TfNSW Reference: SYD21/00418/04  
Departments Reference: SSD-16928008

**EXHIBITION OF EIS – NEPEAN HOSPITAL REDEVELOPMENT PROJECT - STAGE 2 - 35-65 DERBY STREET, KINGSWOOD**

Reference is made to your correspondence seeking comment from Transport for NSW (TfNSW) on the supplementary Response to Submissions (RtS) for the above-mentioned State Significant Development (SSD-16928008).

Attachment 1 – Western Loading Dock Swept Paths

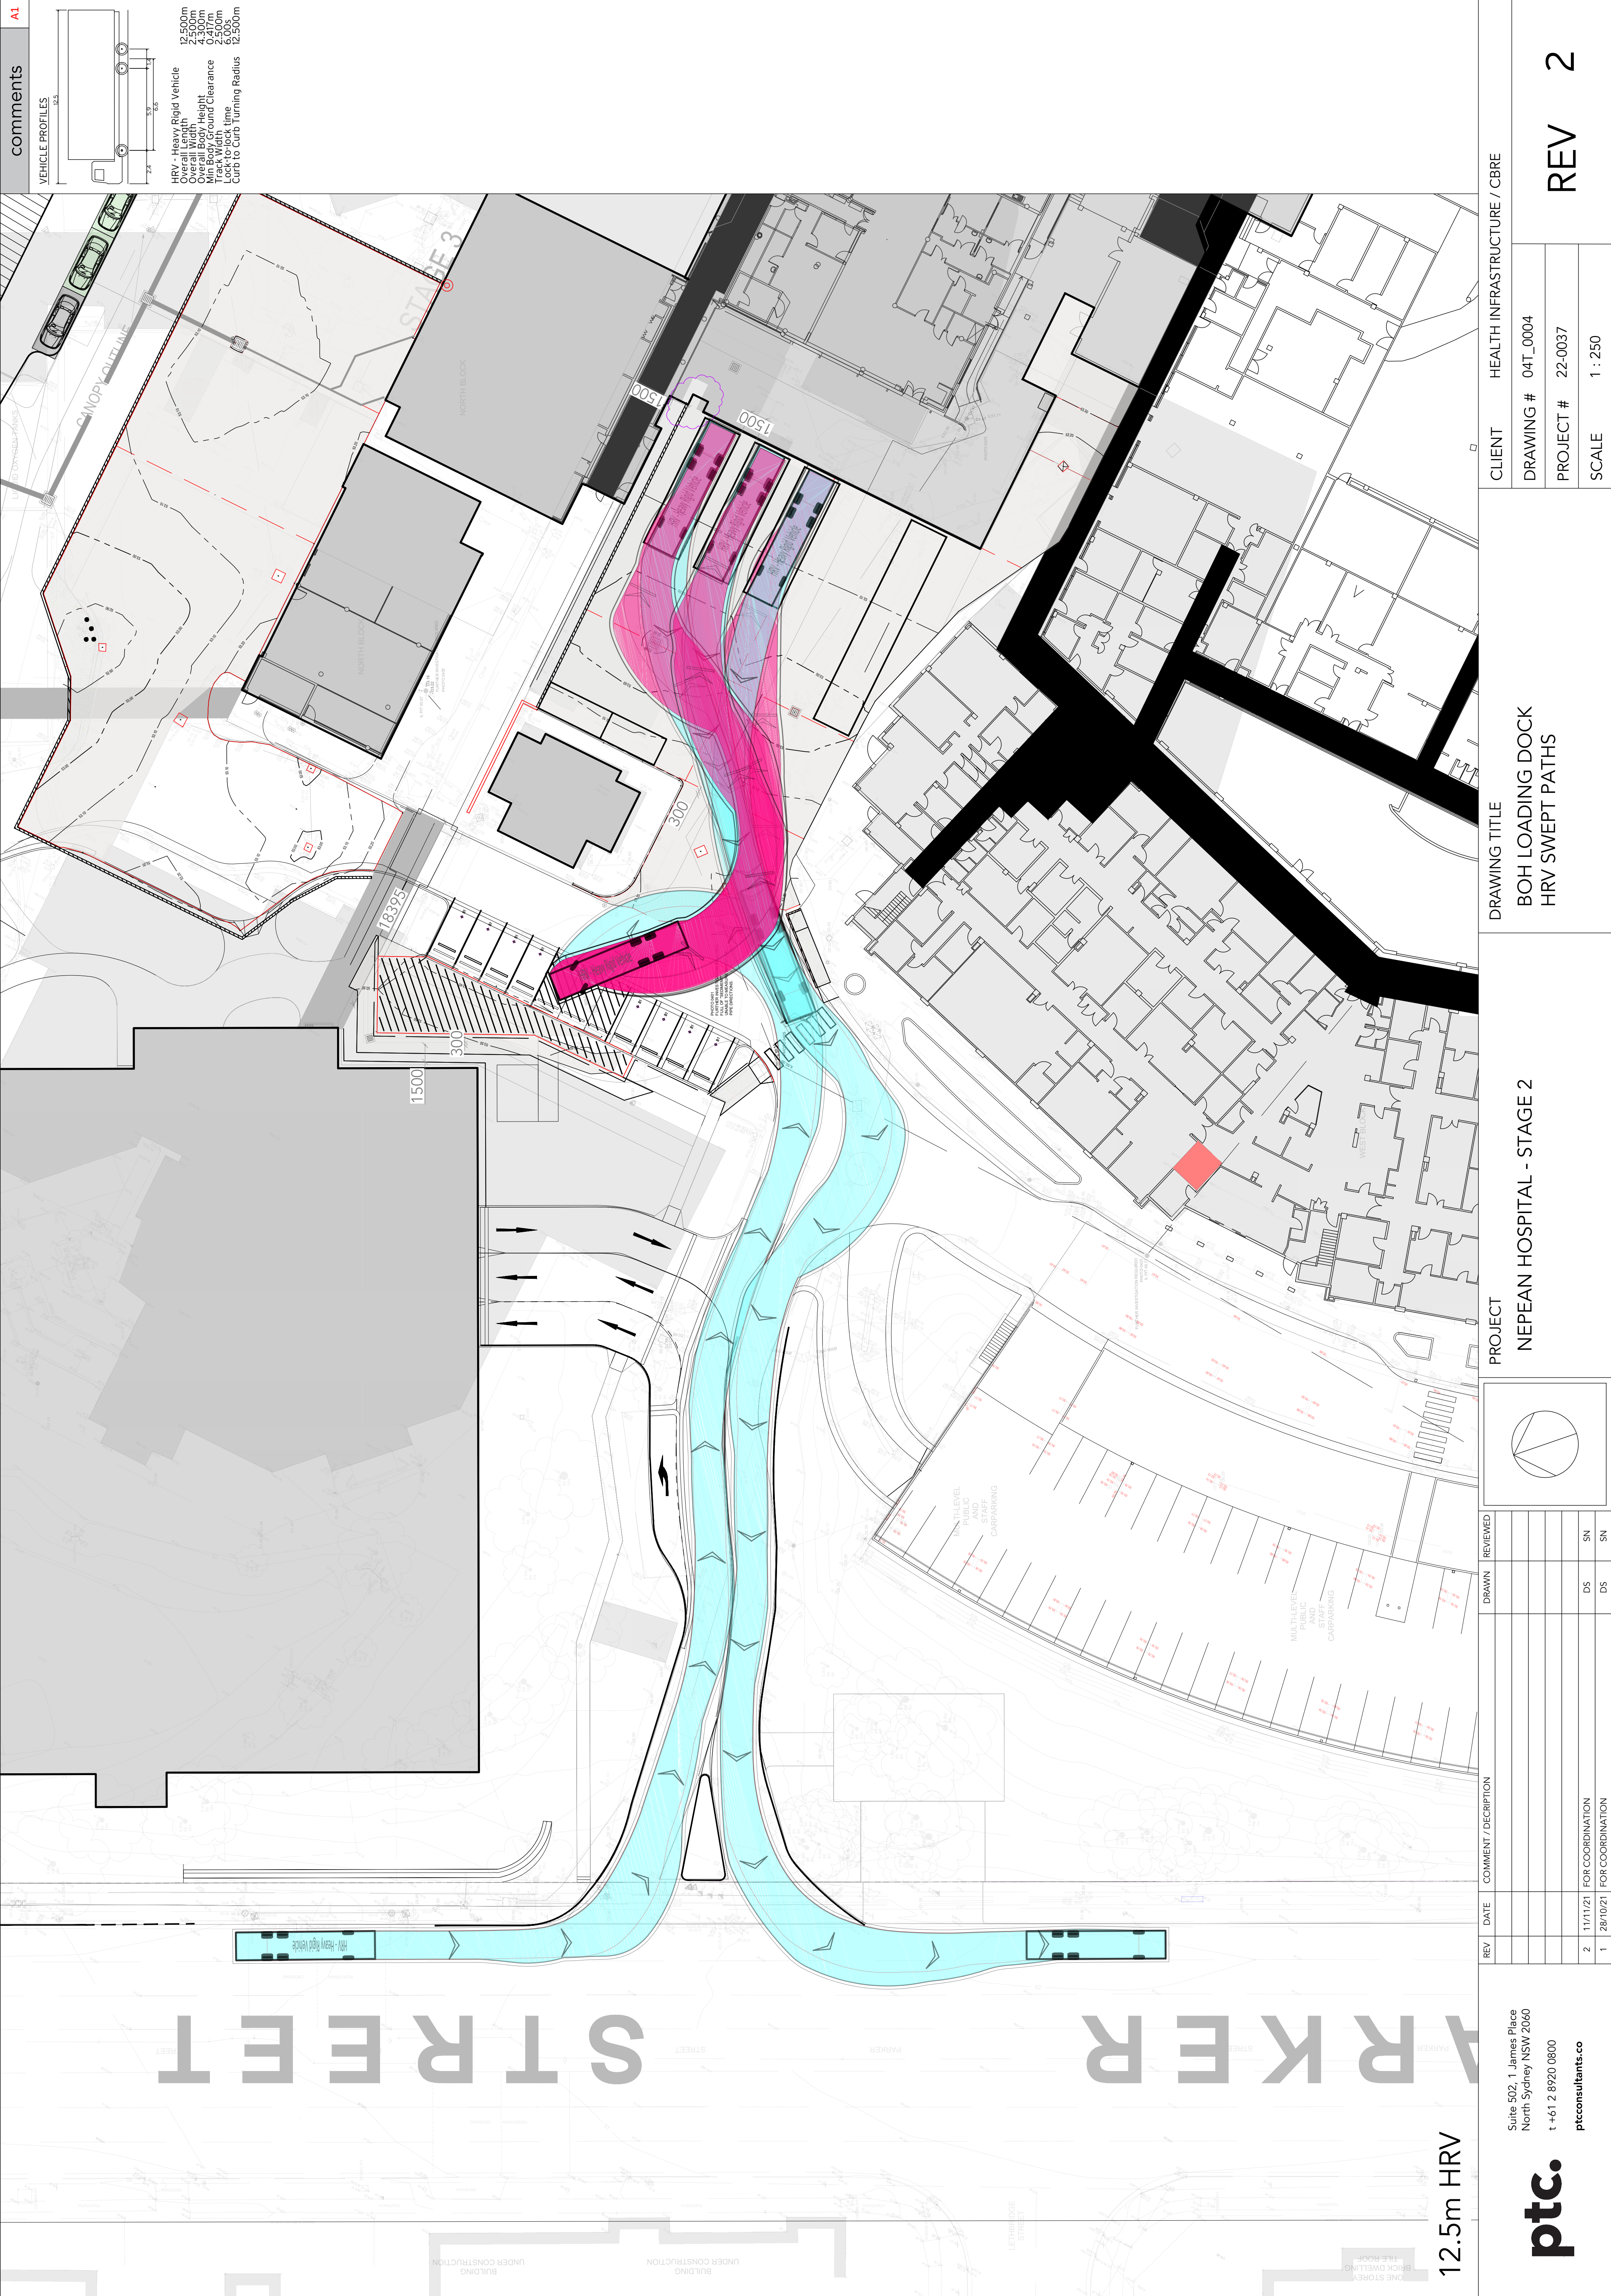
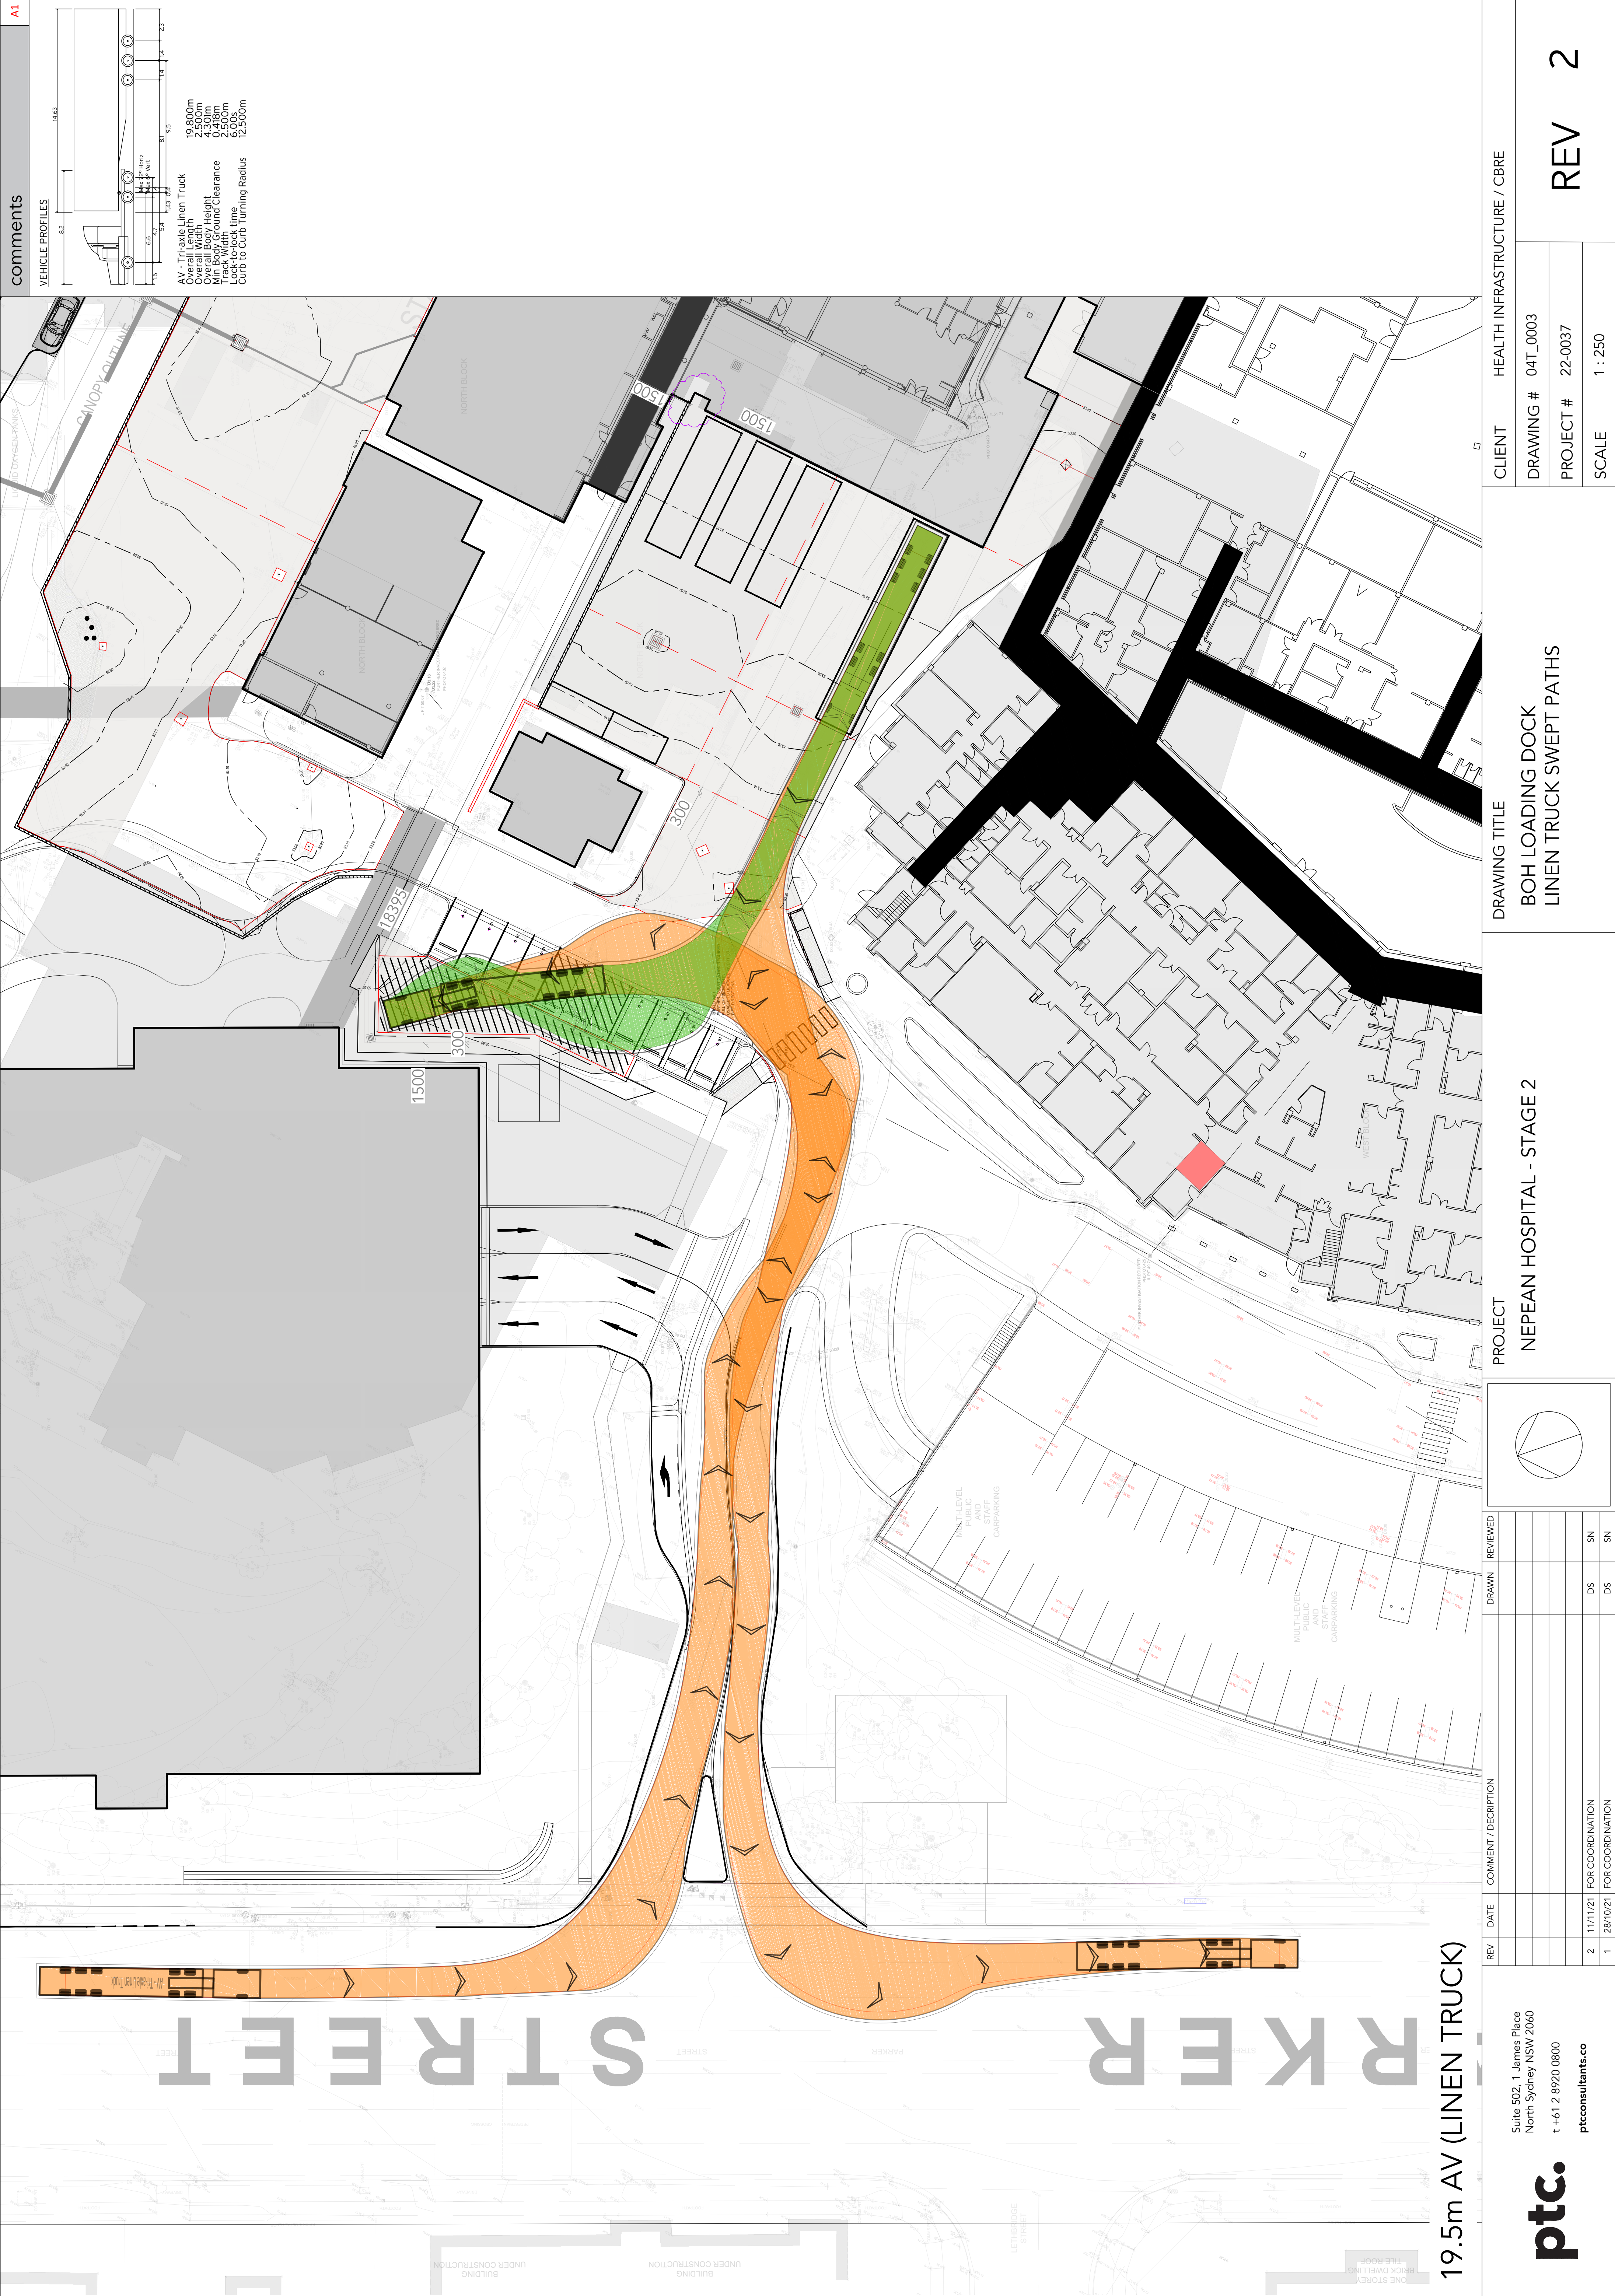
- The swept paths have been updated but appear to have incorrect attachment headings.
- The revised line marking plans do not include line marking;
- Confirm that swept path analysis referred to on page 2 is for Derby Street as previous Transport comments incorrectly referred to access road on Drawing #04T\_003 as Barber St.

TfNSW requests the abovementioned information to be addressed/provided for further assessment prior to the determination of the application. TfNSW will further review and provide response upon receipt of the additional information.
